New Request for Advice on EIS – Trinity Grammar School Redevelopment (SSD-10371) (Inner West)

Proposal: Trinity Grammar School – Summer Hill Campus The ‘Renewal Project’

Property: 113 – 119 Prospect Road, Summer Hill Lot 11 DP 1171965

01 BUILDING ELEVATION
Seaview Maintenance Elevation North
Scale 1:100

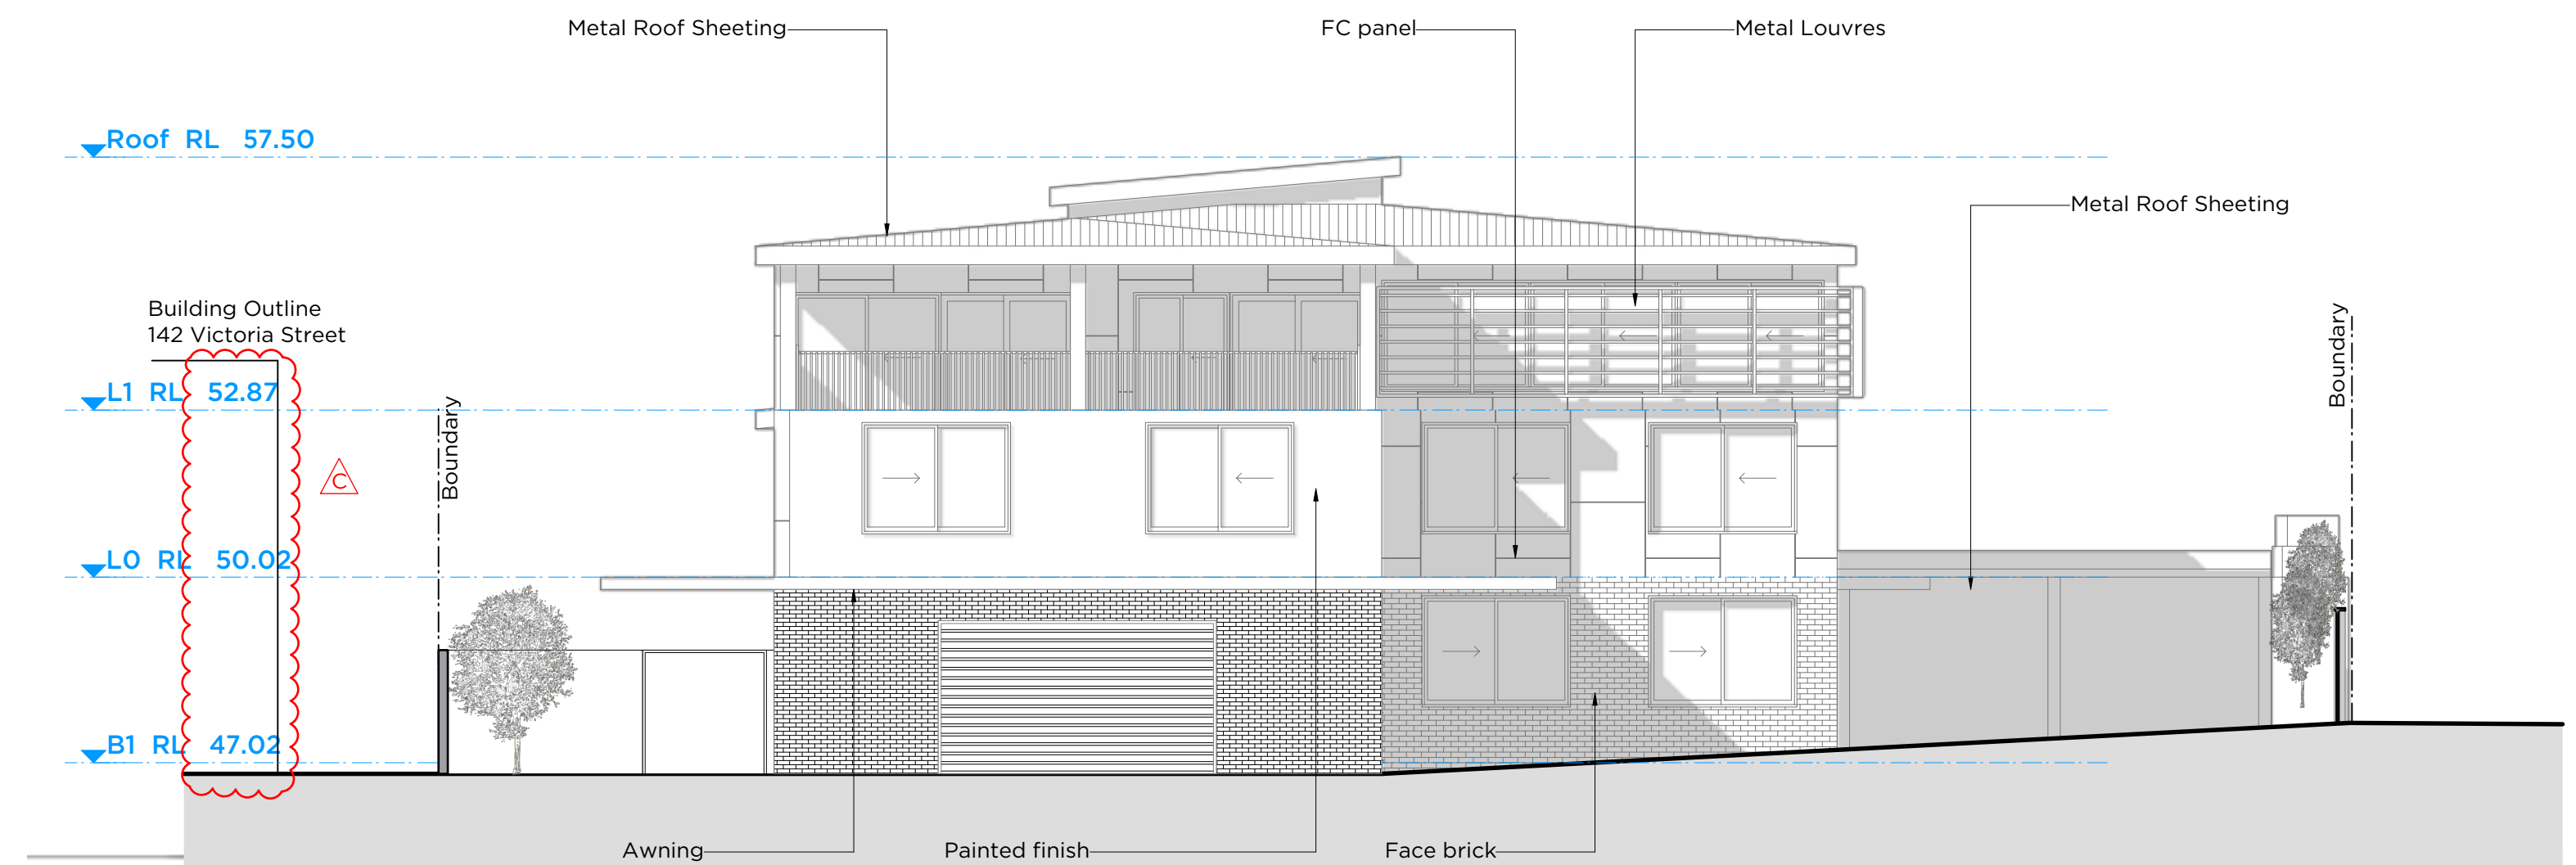
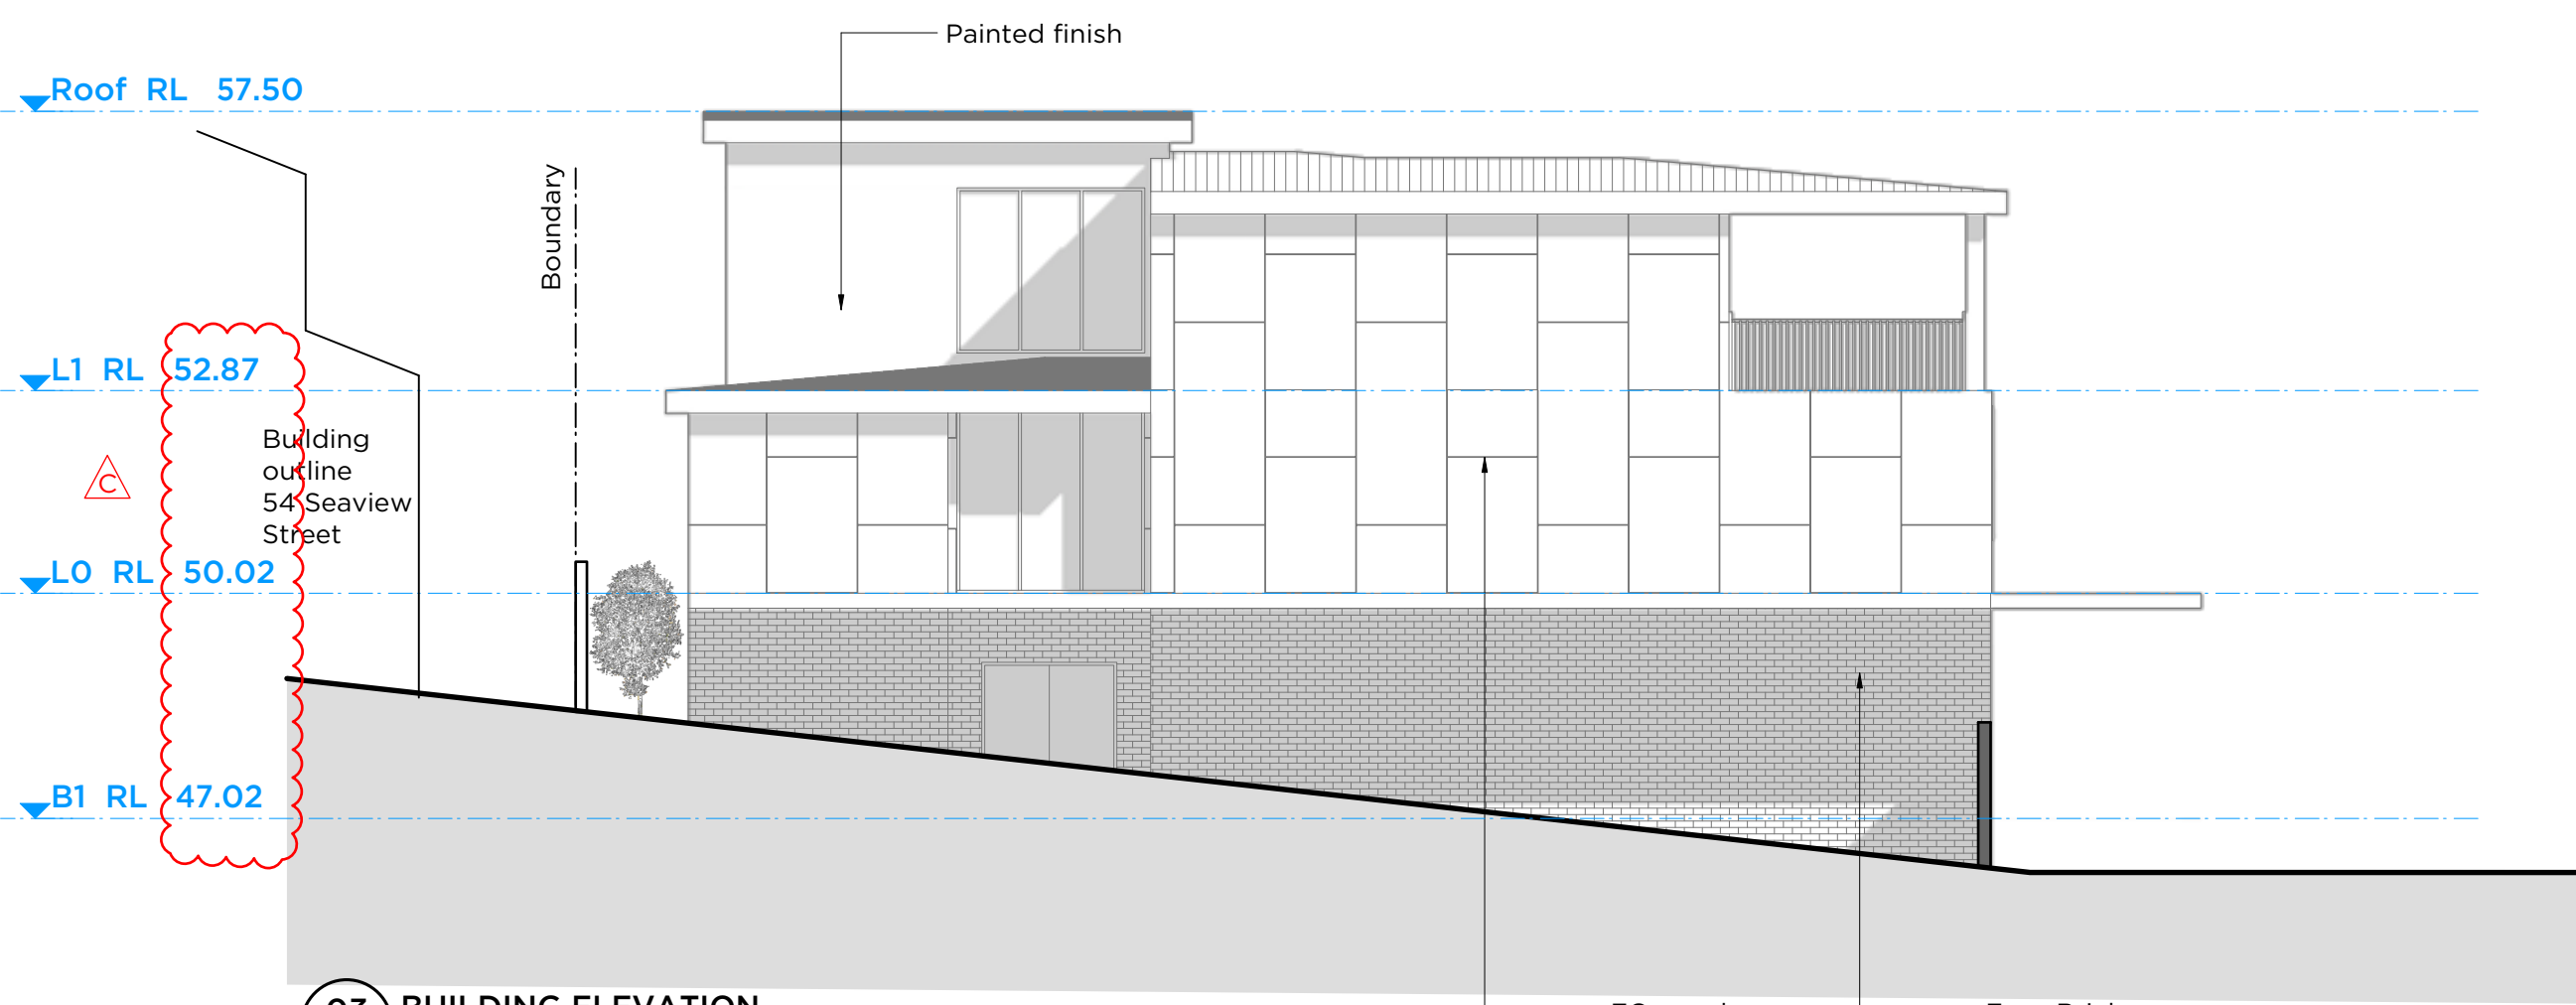
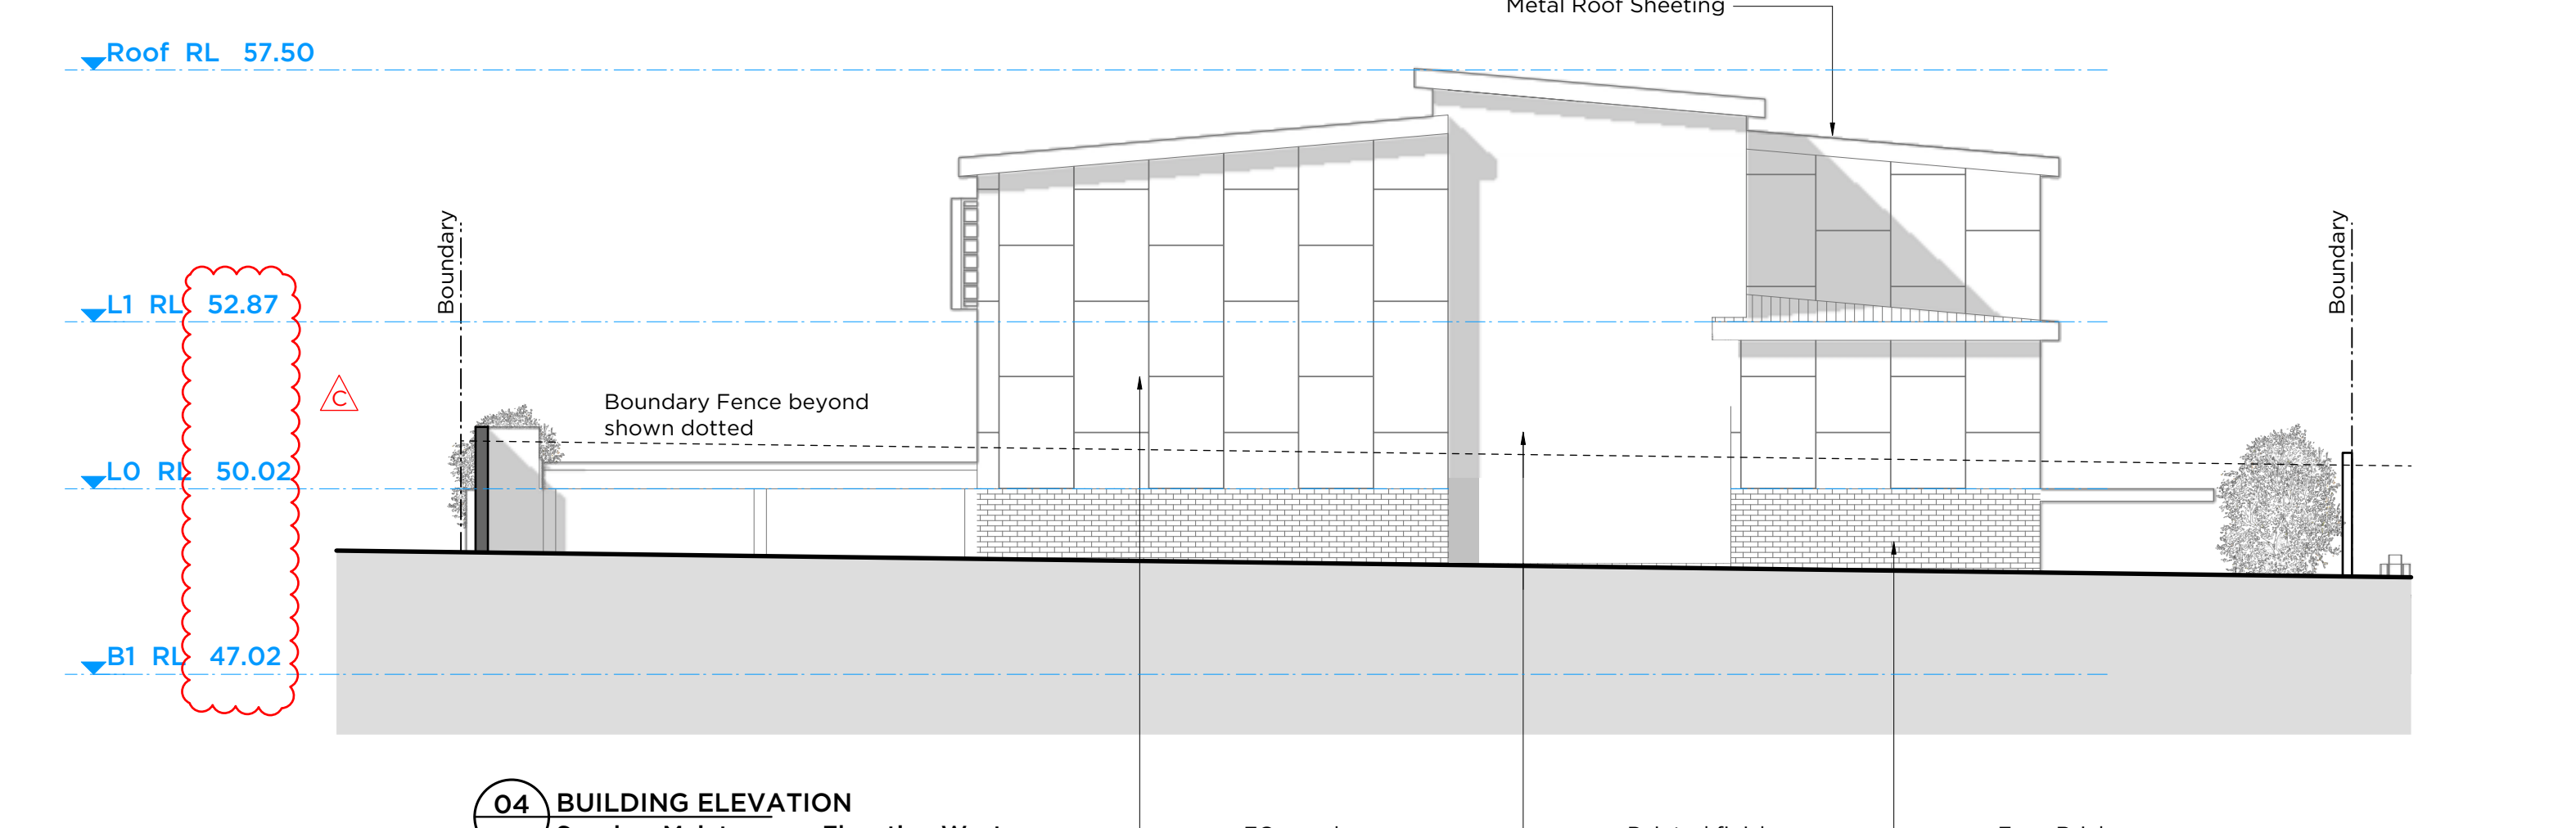
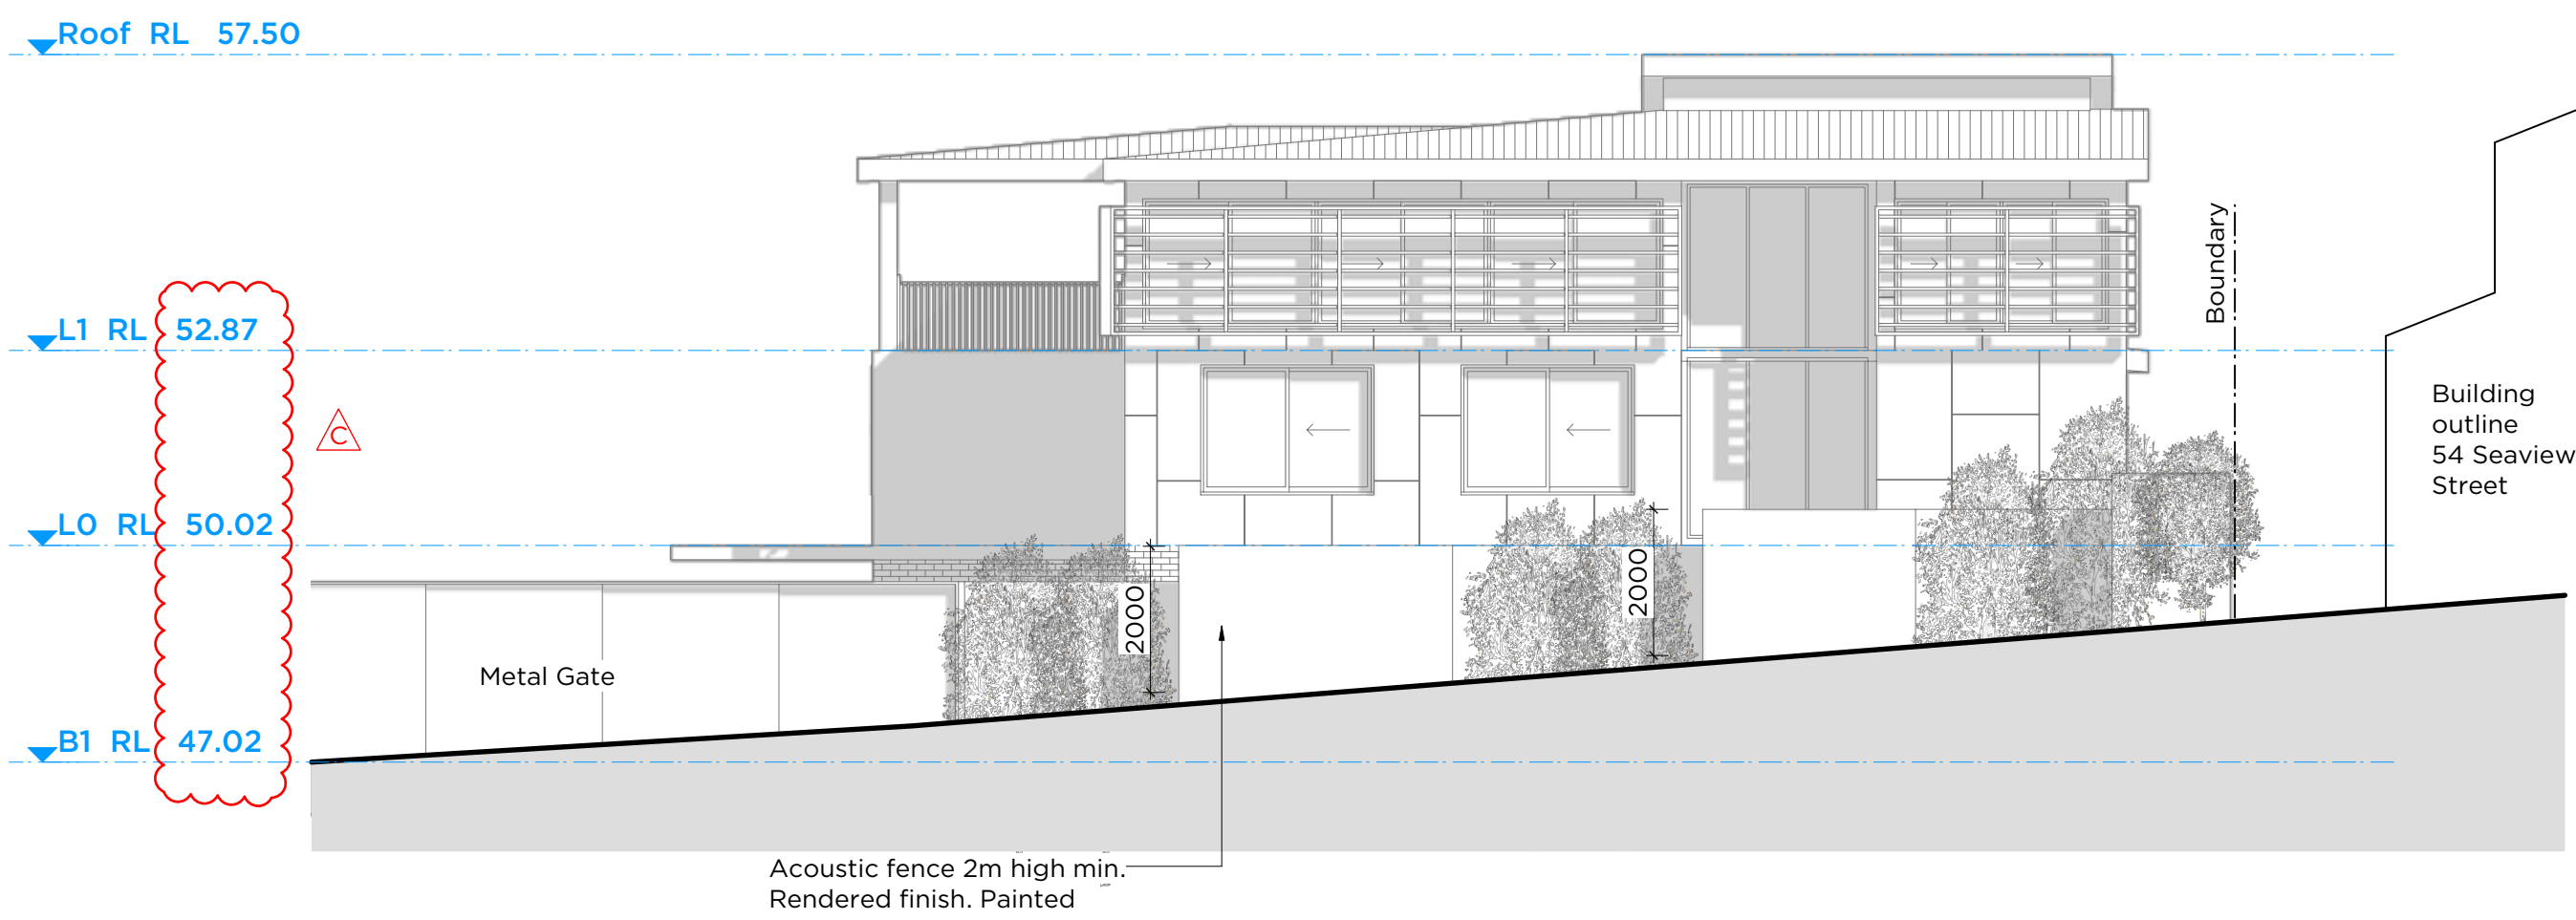
The proposal seeks consent for the demolition of at least four (4) existing dwellings along Seaview Street and the construction of a new Maintenance Building and a loading dock for deliveries. The plans fail to provide sufficient details with regards to the development along Seaview Street. Critical information such as detailed elevations and streetscape analysis have not been provided and therefore a comprehensive assessment of the impacts of the proposal on Seaview Street cannot be made. Additional information regarding the proposed maintenance building and streetscape analysis for Seaview Street must be provided to enable a detailed assessment.

Notations outlined on the plans outline that the applicant wishes to construct a 2m high acoustic wall along Seaview Street. While construction of such a wall would improve acoustic amenity for neighbours, it is expected to result in a poor urban design/streetscape outcome and will offend CEPTED principles. The installation of a 2m high wall on along the street is also likely to attract vandalism and graffiti and will diminish the character of the area. Council raises significant concerns with the future passive surveillance to Seaview Street and the resulting streetscape.
